MORGAN AND MORECAMBE OFFSHORE WIND FARMS: TRANSMISSION ASSETS

Works Plans - Onshore and Offshore

Deadline: Deadline 6
PINS Reference: EN020028

Document reference: B7/F05
Rev: F05

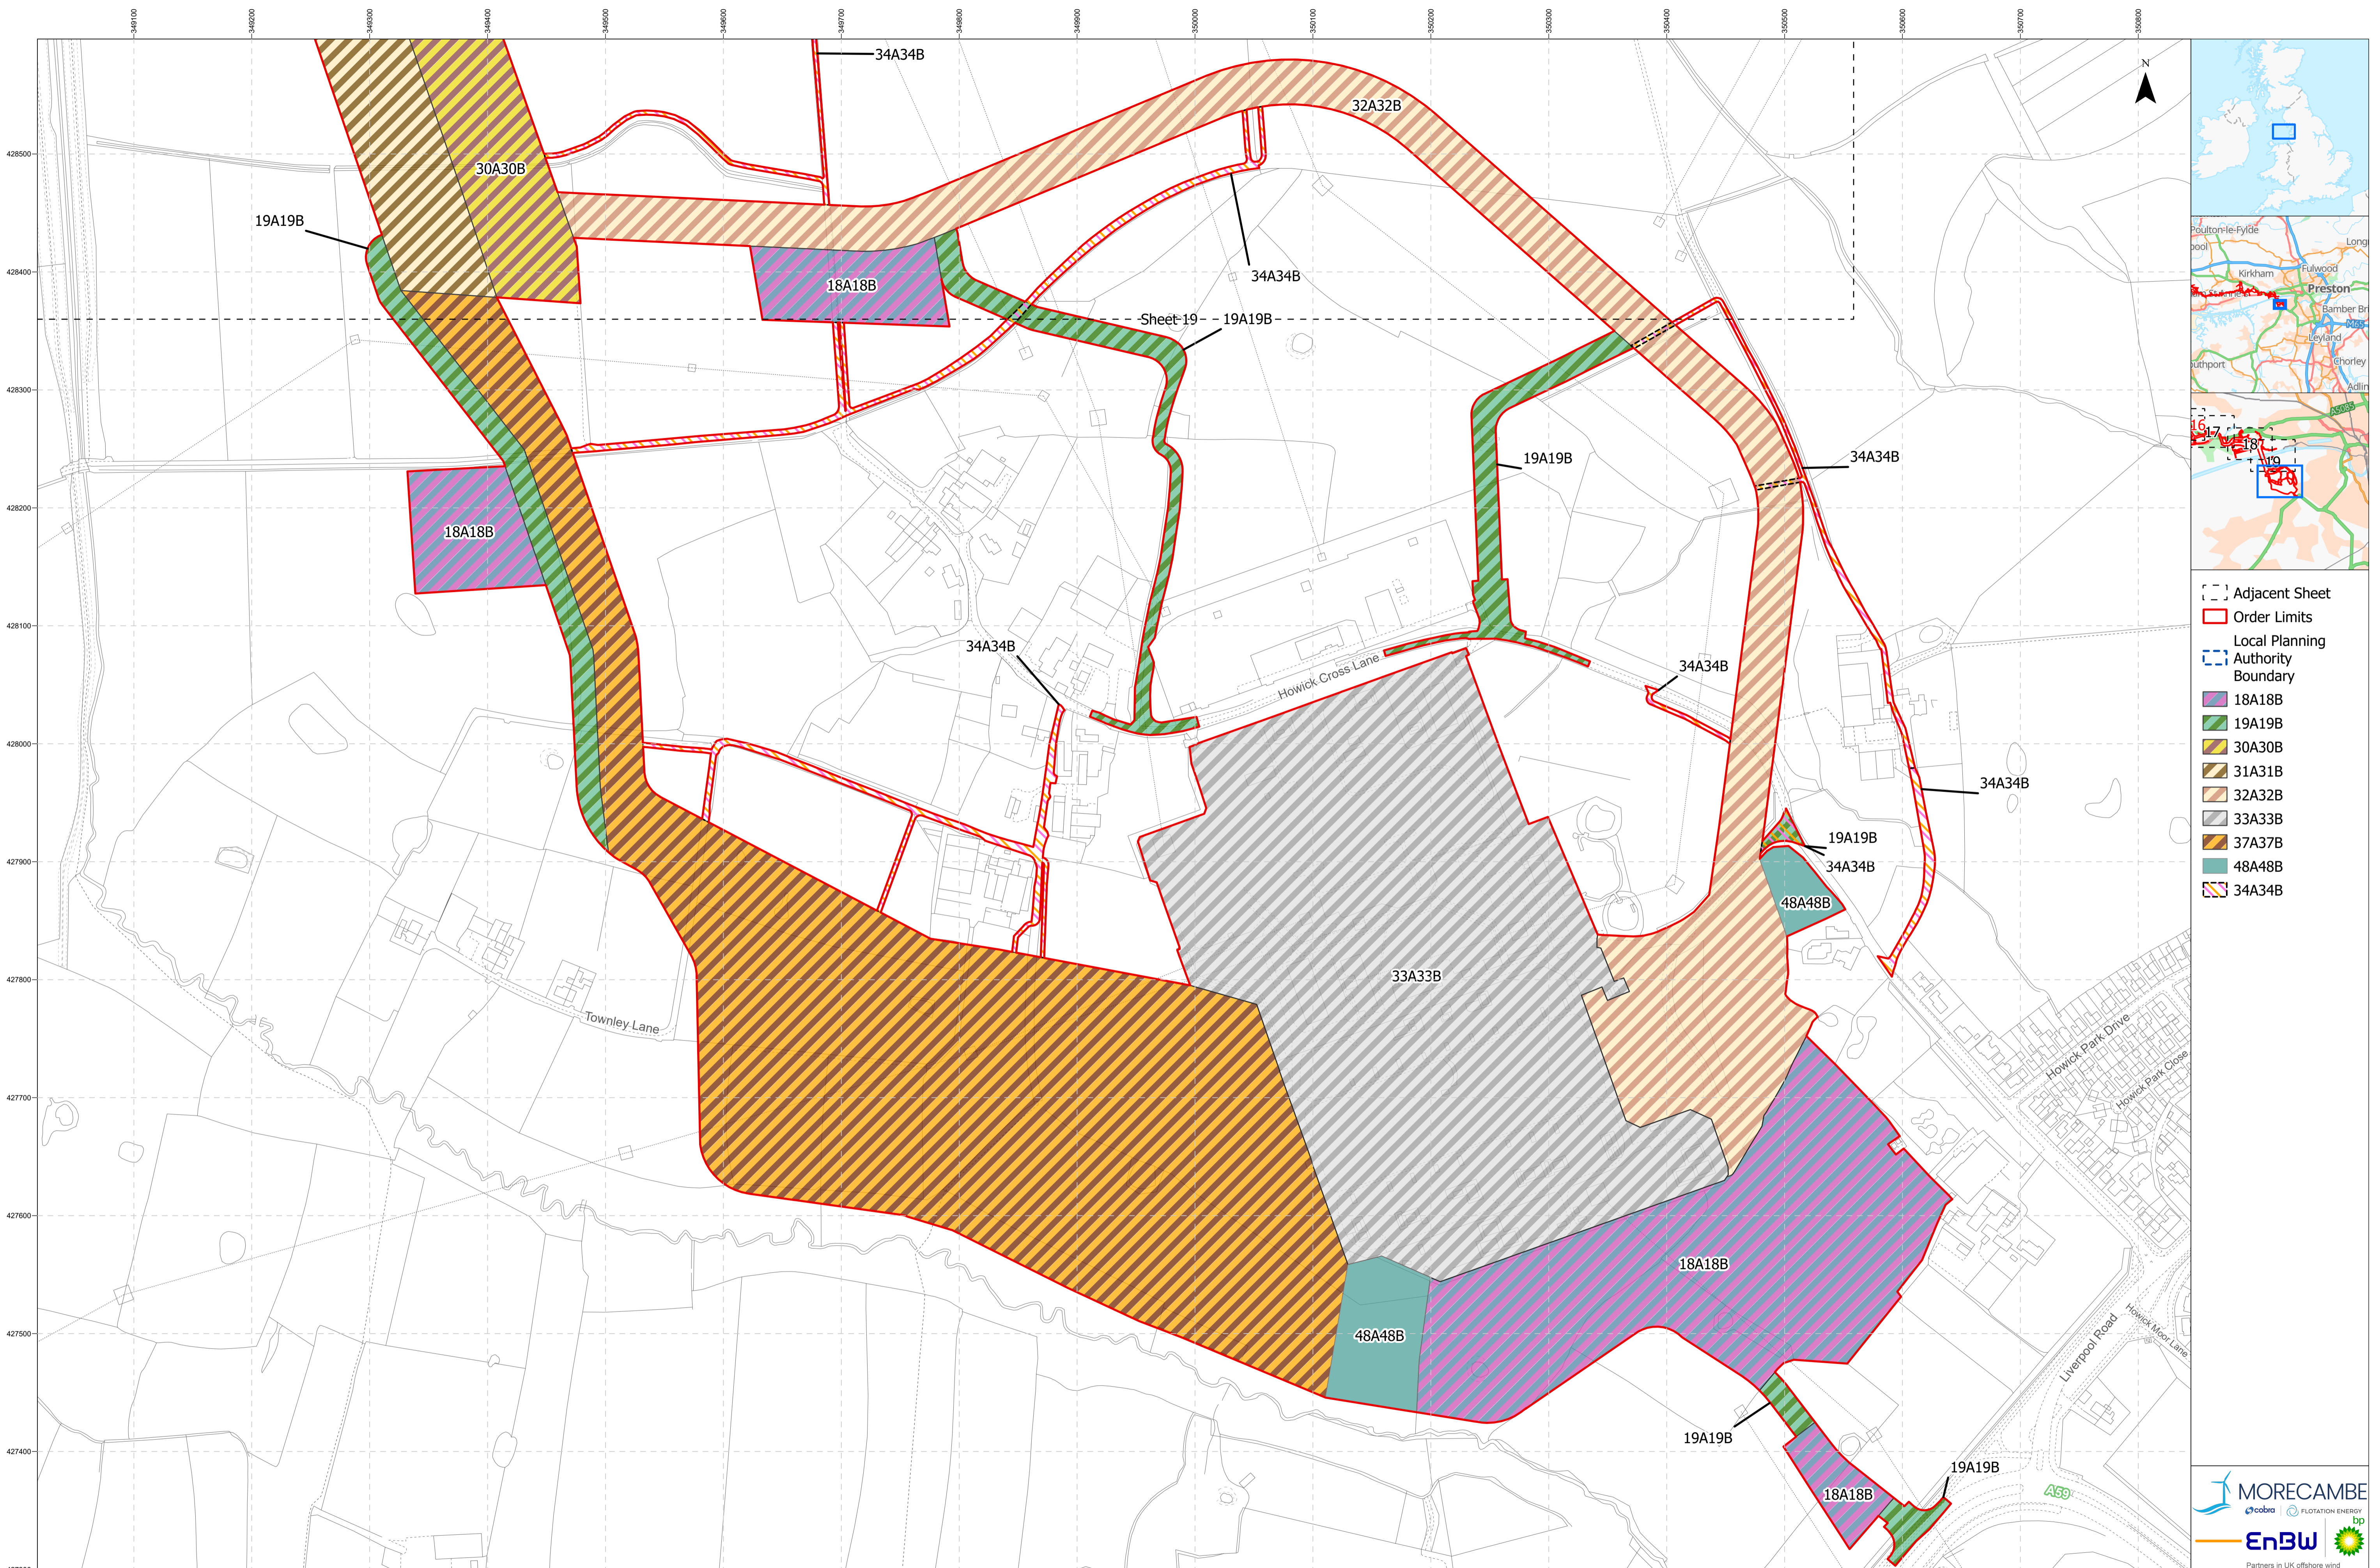
Sheet Number	Change requested by	Change Made	Reason for Change	Revision	Submission deadline
19	The Applicants	The Morecambe permanent access (Works No. 34B) to the 400kV grid connection cable corridor on the northern bank of the River Ribble (Works No.25B) has been aligned with the existing pathway.	A review of the works plans identified that permanent access (Work No. 34B) was wider in one section, therefore it has been reduced to align with the existing pathway.	F02	S51 advice update
19	The Applicants	The permanent access (Work No. 34A34B) to the Morgan and Morecambe 400kV grid connection cable corridor on the northern bank of the River Ribble (Works No. 25A and 25B) has been refined.	A review of the works plans identified the need for the permanent access (Works No. 34A34B) to be refined, to ensure that the permanent access allows both projects to access their respective cable corridors.	F02	S51 advice update

19	The Applicants	Permanent access (Works No. 34A34B) has been extended over Works No. 30A30B to ensure access to the 400kV grid connection cable corridor on the southern bank of the River Ribble (Works No. 31A31B)	A review of the works plans identified that permanent access (Work No. 34A34B) to the 400kV Grid Connection Corridor (Work No. 30A30B) was previously omitted.	F02	S51 advice update
19	The Applicants	Permanent access (Works No. 34A34B) has been extended over Works No. 32A32B and 18A18B to ensure access to the 400kV grid connection cable corridor on the southern bank of the River Ribble.	A review of the works plans identified that permanent access (Work No. 34A34B) to the 400kV Grid Connection Corridor (Work No. 30A30B and 29A29B) was previously omitted.	F02	S51 advice update
20	The Applicants	Permanent access (Works No. 34A34B) north of Howick Cross Lane has been refined.	A review of the works plans identified that permanent access (Work No. 34A34B) was not required extend over the 400kV Grid Connection Cable Corridor (Works No. 32A32B) at this location.	F02	S51 advice update
